870 Ophir Rd Summer Hill Creek NSW 2800 www.cwecouncil.com

Monday 16 August 2021

Submission of Objection: Bowdens Silver Mine – Amendment (SSD-5765)

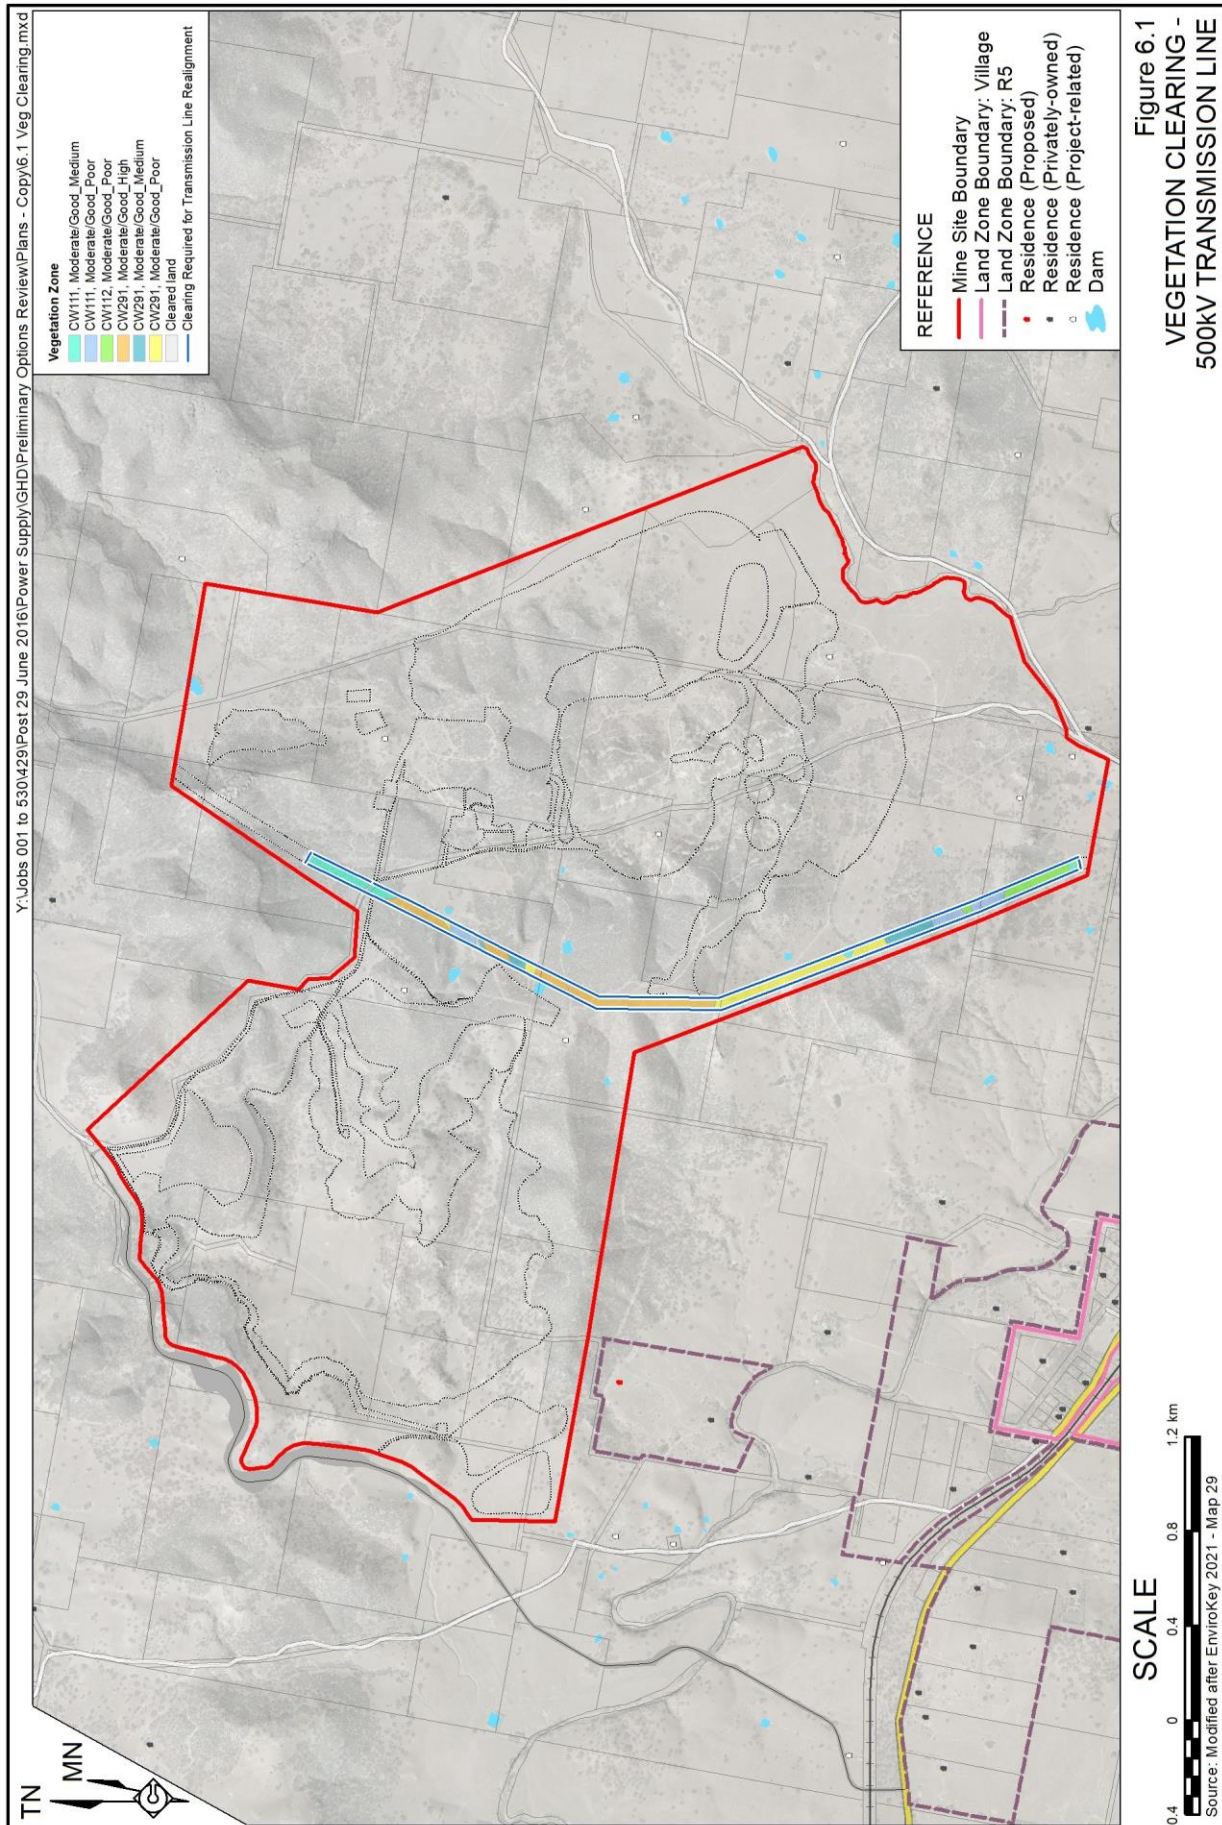
The maps to demonstrate records of threatened species and endangered ecological communities provided in the amendment report are highly inadequate.²

Fig 6.2 does not have an overlay of the proposed re-alignment of the transmission line as in Fig 6.1. It is very difficult to understand the biodiversity impacts as described.
